**Addendum No. 1**

RE: Contract # C204675

**Haywood County (U-5888)**

INTERSECTION OF US-23 BUSINESS AND WALNUT STREET

PROJECT REFERENCE NO. <b>U-5888</b>	SHEET NO. <b>4</b>
RW SHEET NO.	HYDRAULICS ENGINEER
ROADWAY DESIGN ENGINEER 2/6/2021	2/6/2021

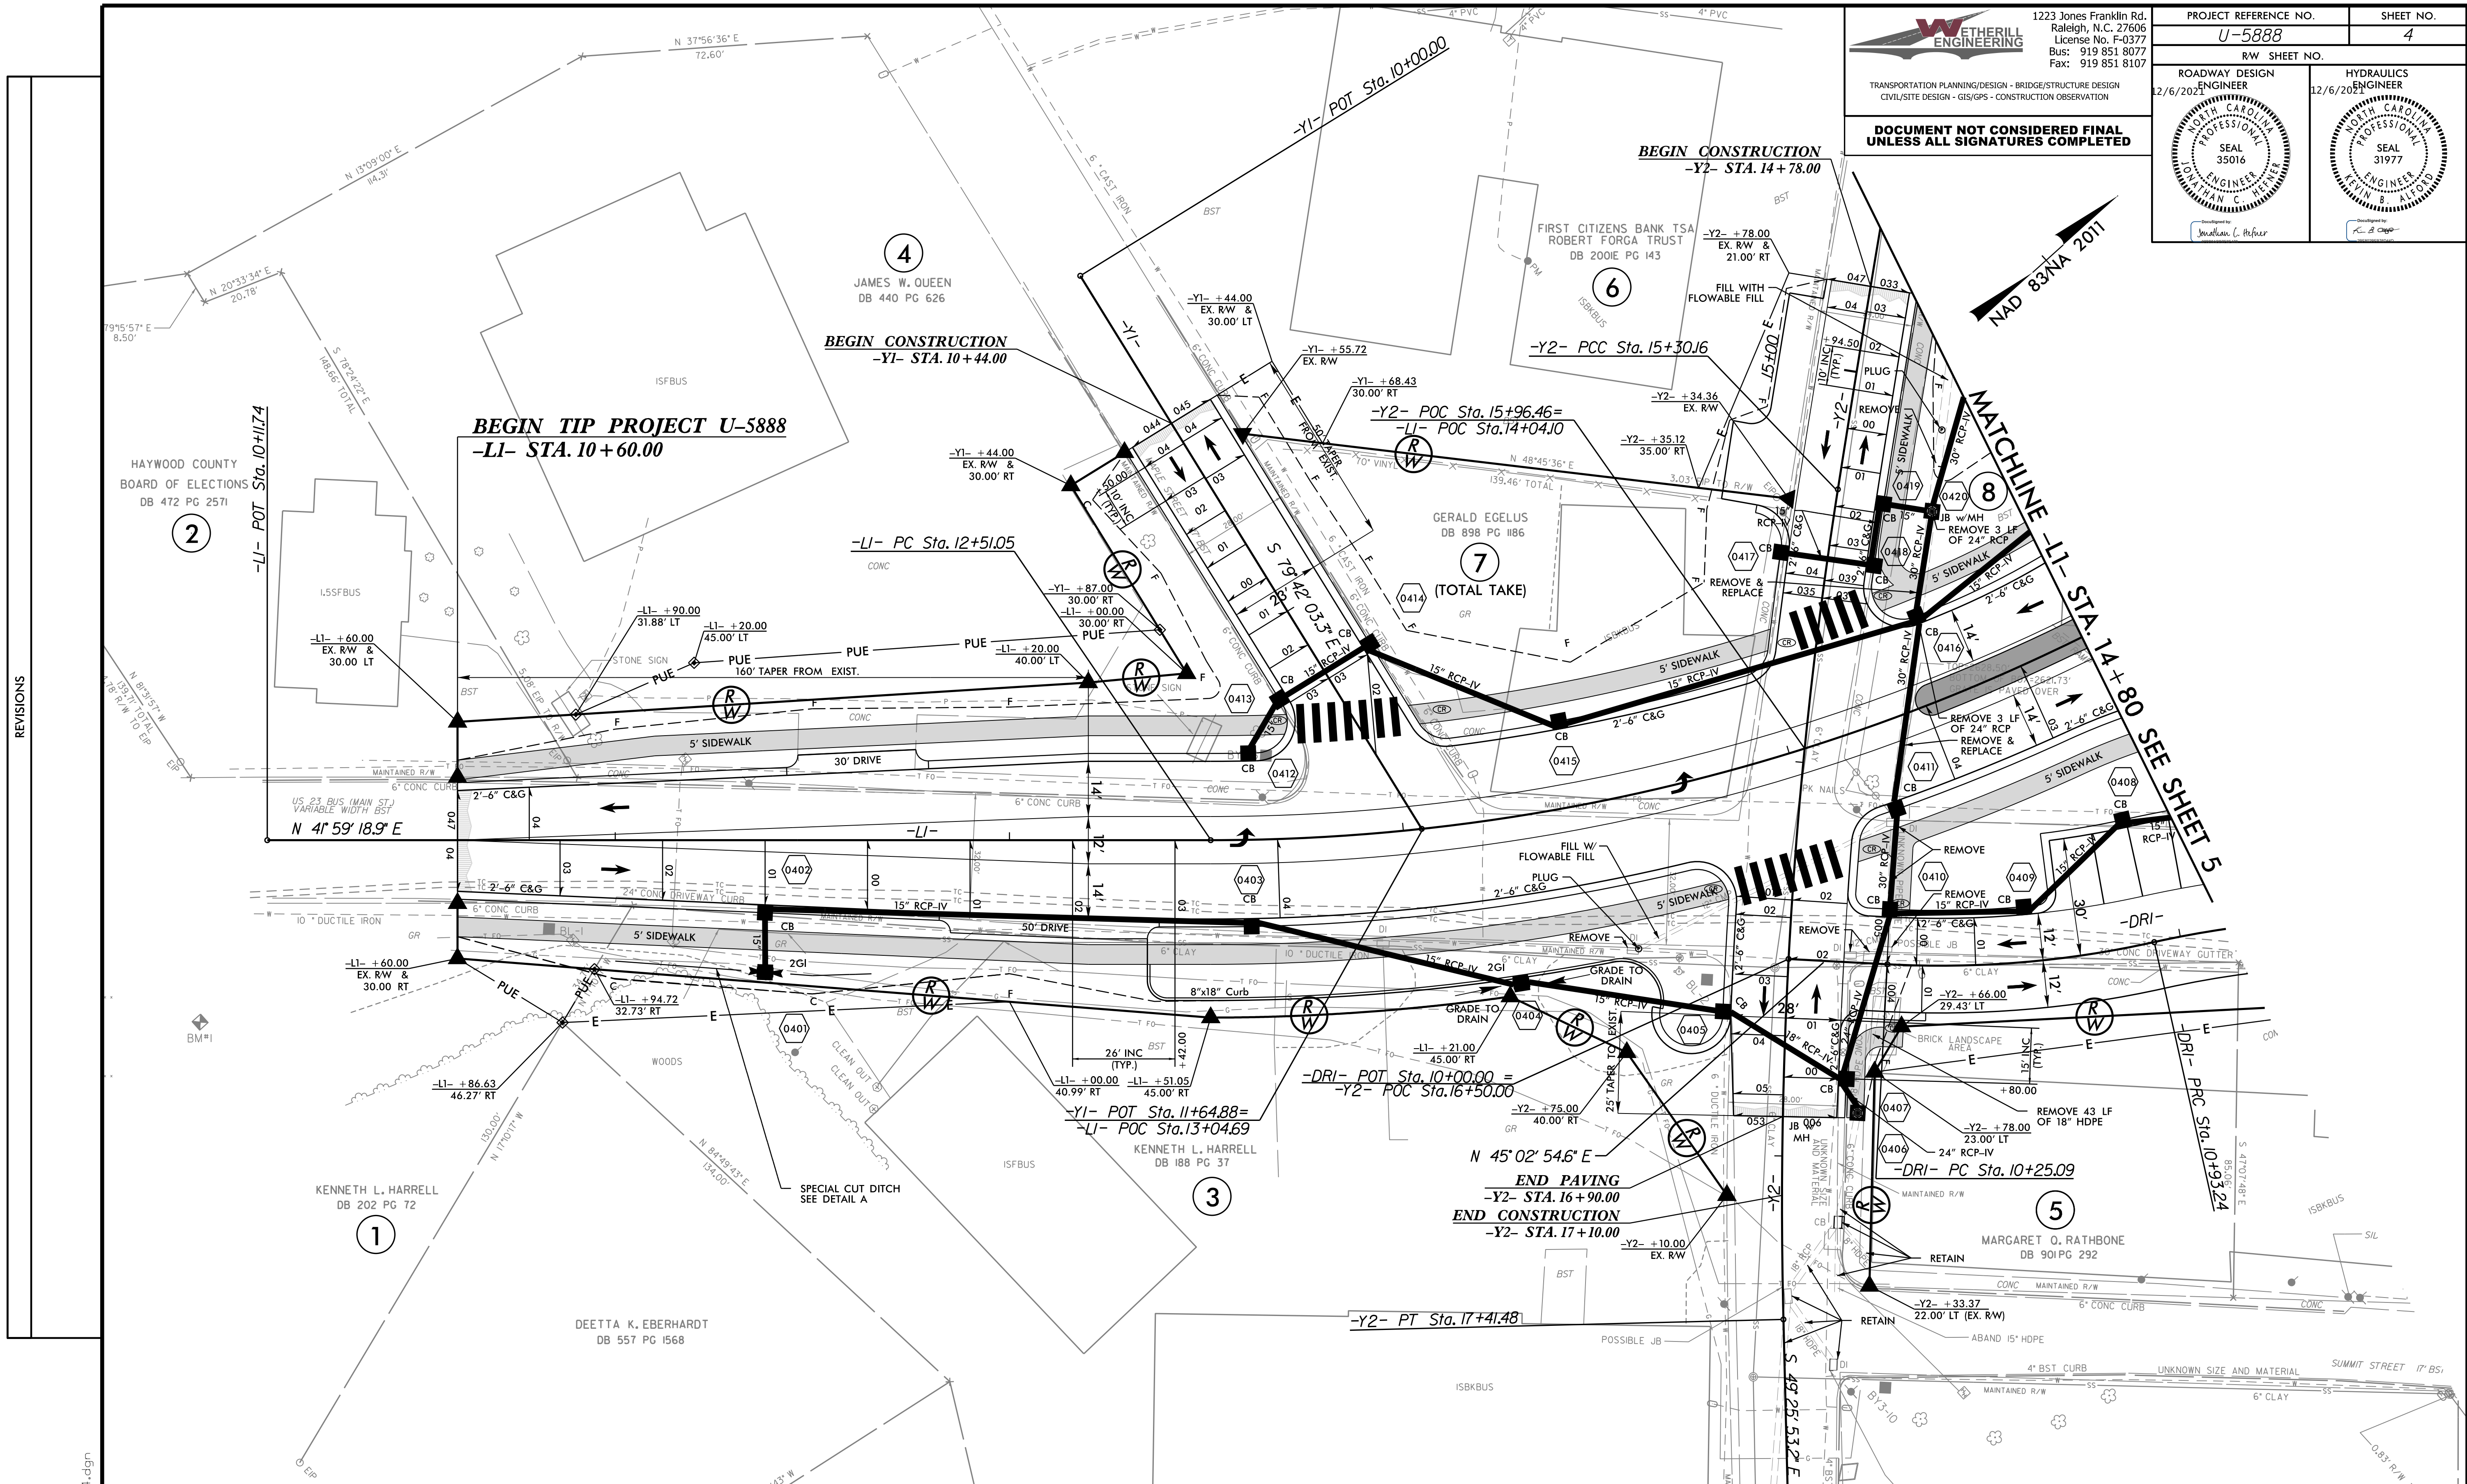
Sheet No.	Revision
4	Revised to show existing gas line and 2 fiber optic lines
UC-5	Revised to show existing gas line and 2 fiber optic lines
UO-4	Revised to show existing gas line and 2 fiber optic lines
